# PORTLAND MAINE

June 7, 2007

RE: 33 Huntington Avenue – 409 C030 – R3 – Conditional Use Application to add an accessory dwelling unit

SITE PLAN

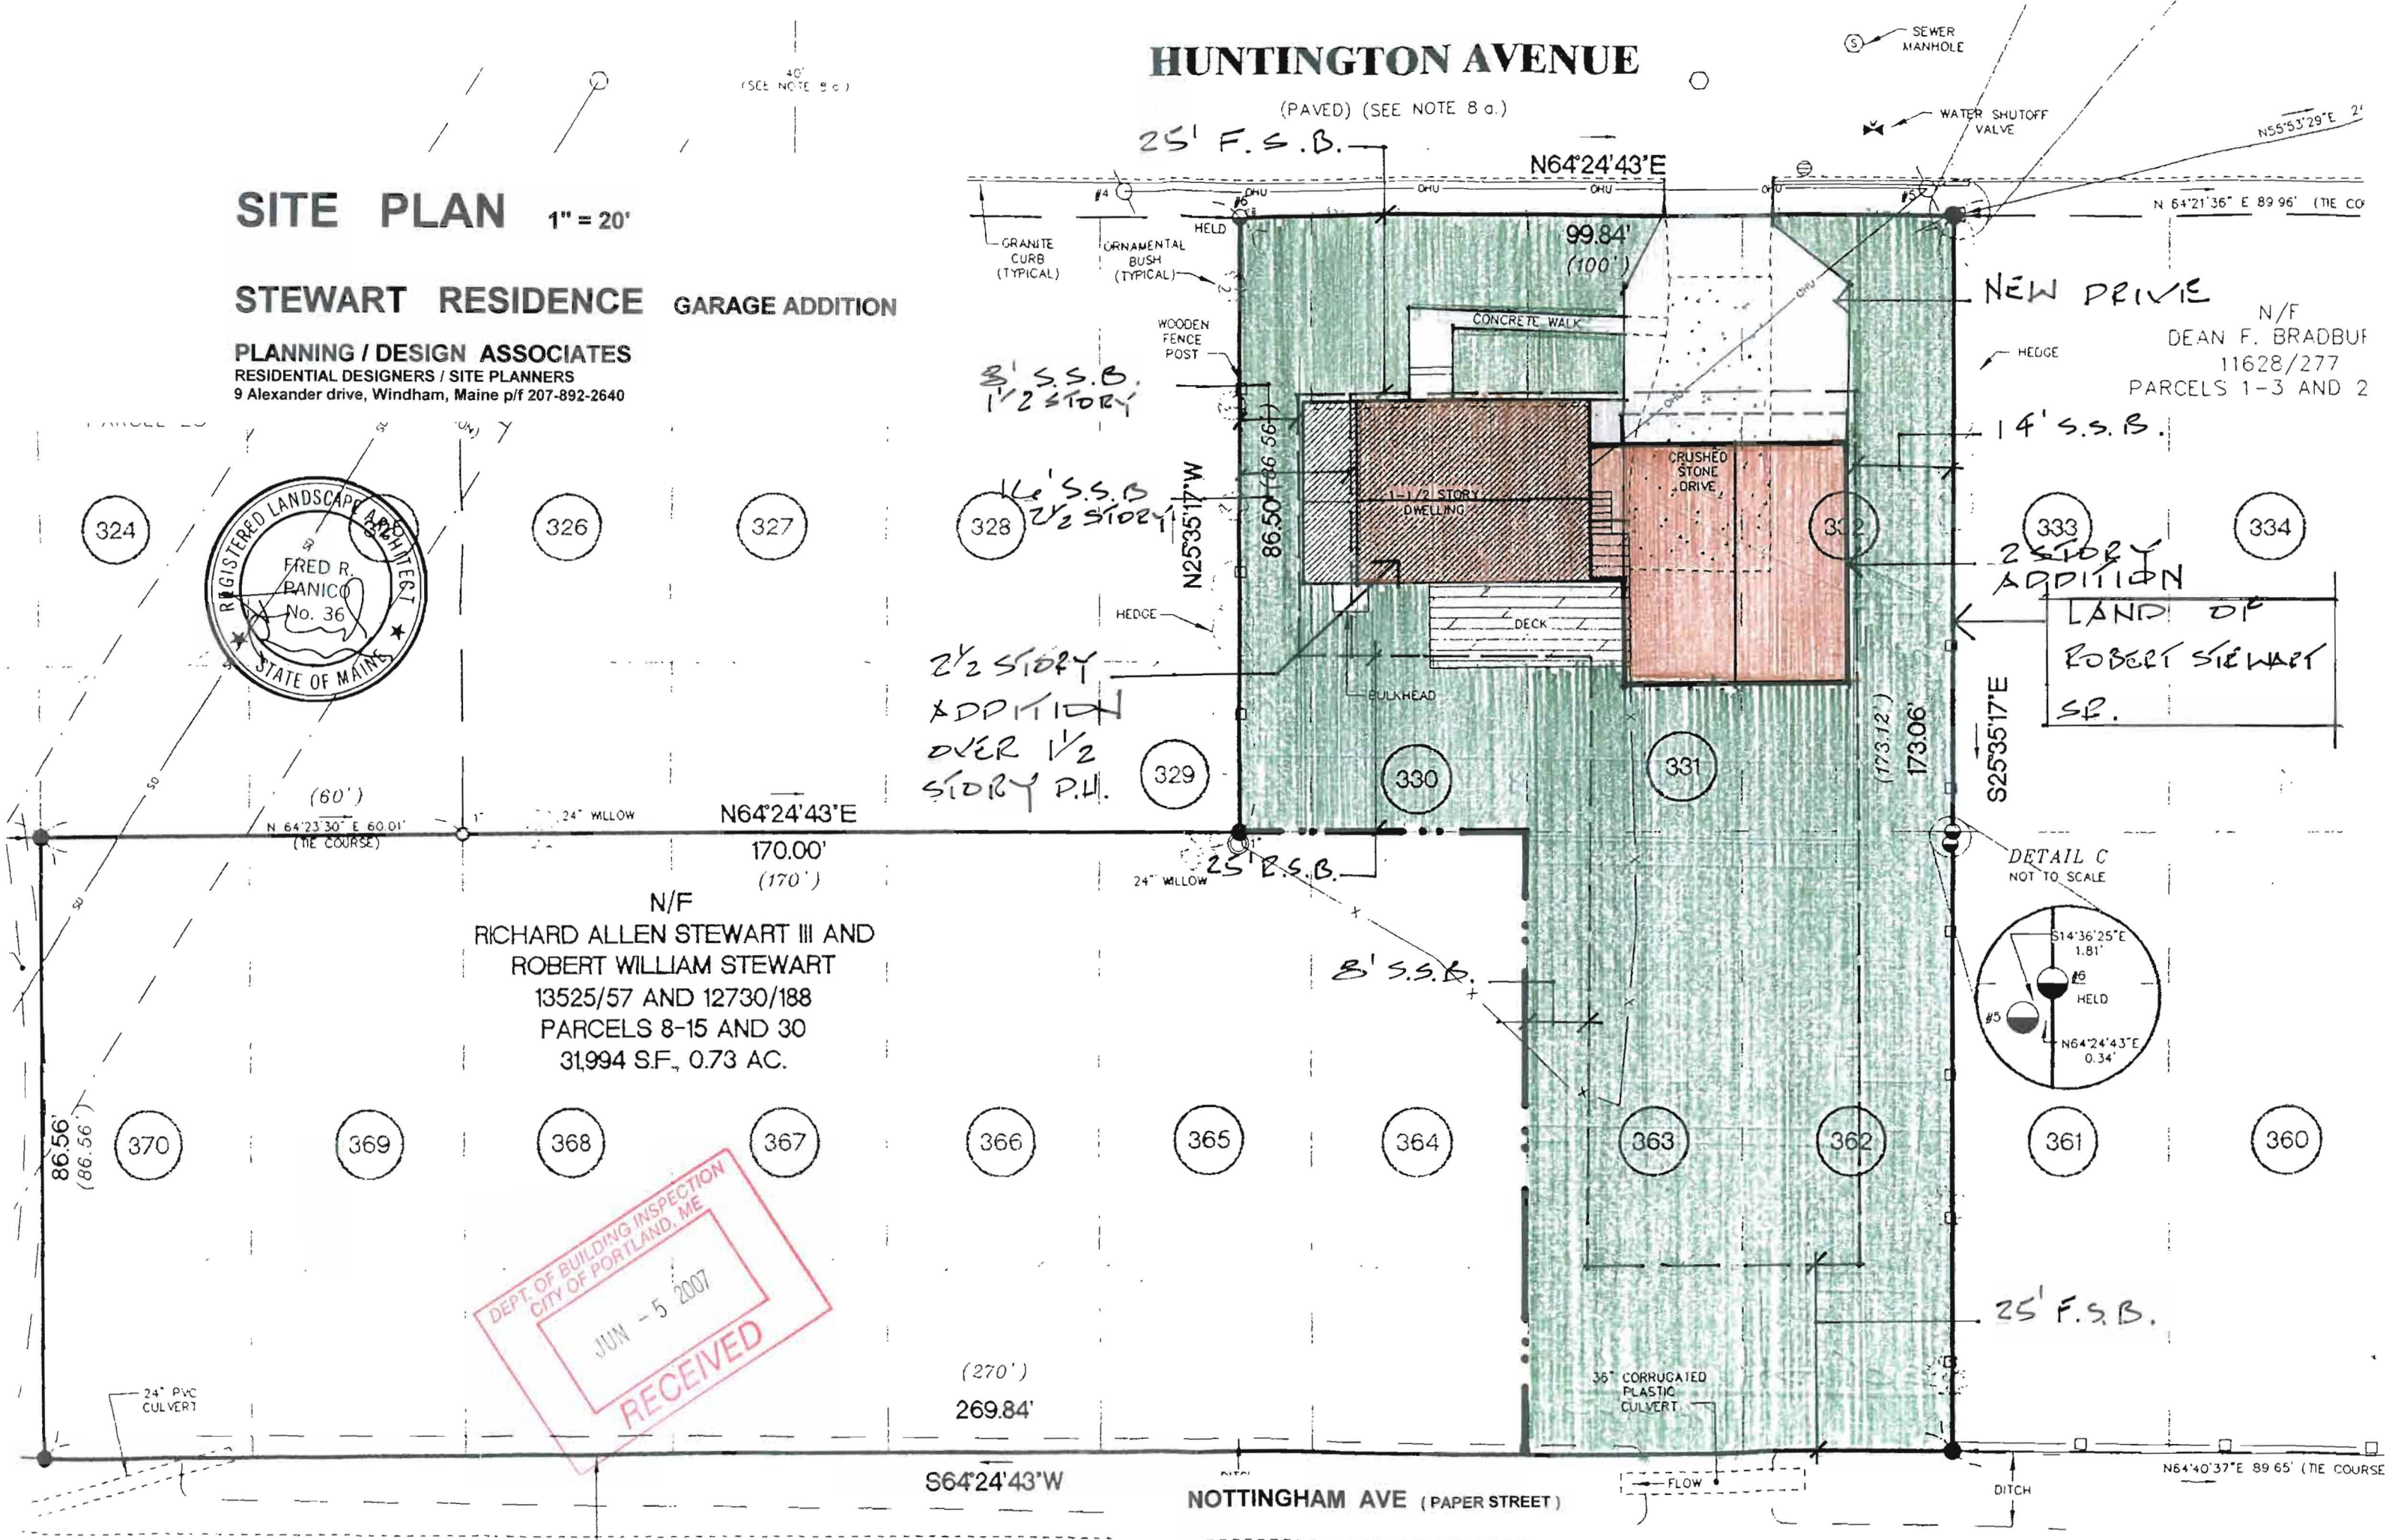
This letter is a follow up to the telephone conversation we had yesterday. You submitted a revised plan on June 5, 2007 for the garage addition and accessory dwelling unit for Robert Stewart's application for the Zoning Board of Appeals for a conditional use to add an accessory dwelling unit to his house at 33 Huntington Avenue. Your revised plan and letter addresses many of the concerns I had on the plan and letter you submitted on May 9, 2007. Your revised plan has raised a new concern though. In trying to create a greater amount of gross floor area in the house so that the accessory dwelling unit may be bigger, you have proposed an addition to the house, which would create a second floor. Section 14-90(d)(3) of the ordinance states that the setback for a side yard for a two-story building is fourteen feet. The site plan that you submitted for the addition shows the side yard setback as nine feet, so your proposal to put a second floor on the existing house does not meet the required setback. Section 14-47 of the ordinance gives a definition of what constitutes a story. Since the side setback does not allow you to add a second story to the existing house, you are not able to create as much gross floor area. As a result, the area of the proposed accessory dwelling unit exceeds the thirty percent maximum square footage allowed. We will need to see a revised plan that meets the criteria under section 14-88(a)(2) for an accessory dwelling unit.
